Our ref: Calala Battery Energy Storage System (SSD-52786213)

17/05/2024

Subject: Request for Additional Information

Figure 3.1 – Comparison between original and proposed heavy vehicle routes

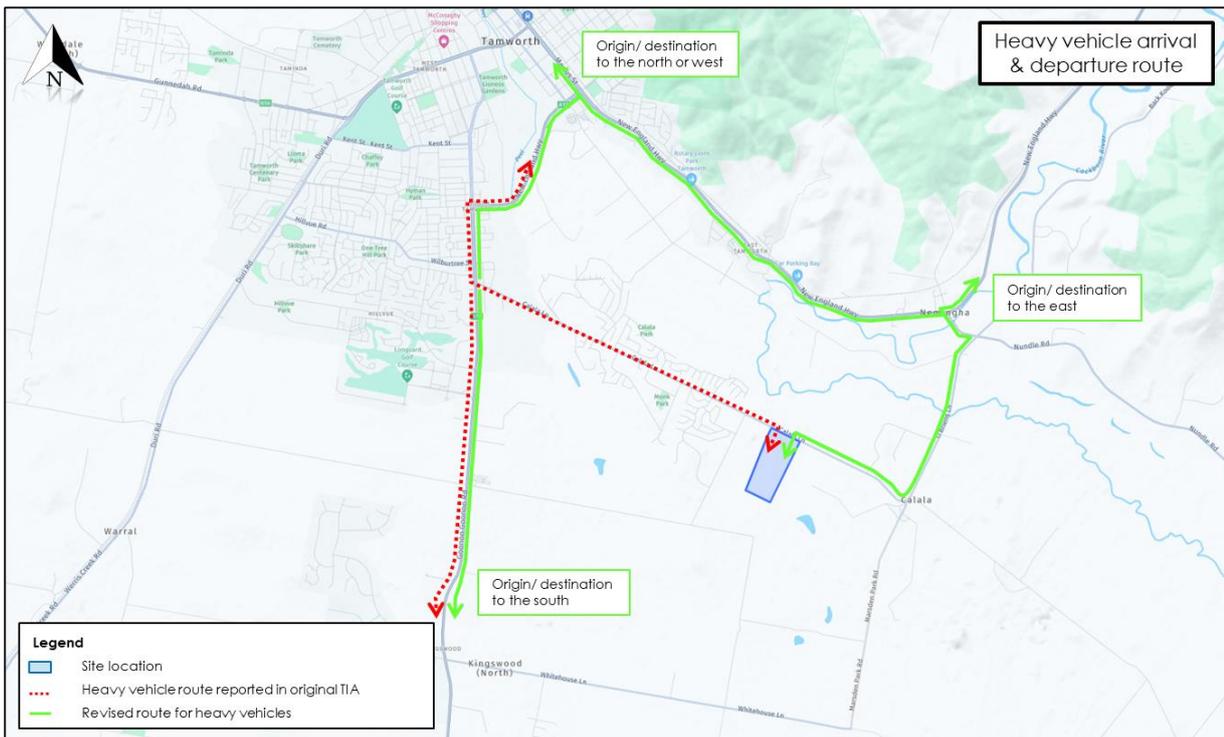
- clarification on the access routes to the site for light vehicles, heavy vehicles, and heavy vehicles requiring escort.
- for the proposed primary and secondary heavy vehicle routes:
 - o describe any proposed flooding risk, and identify any appropriate mitigation, on the proposed primary route for heavy vehicles; or
 - o if a secondary route is proposed, provide an assessment of that route (including traffic, transport, road noise, biodiversity, heritage and amenity) and outline if any road works are required (such as intersection upgrades, road sealing, and road widening), confirming that Council support the use of the route.
- Provide evidence of consultation with TfNSW, Council and any receivers (including residences on the proposed access routes) regarding traffic and transport.
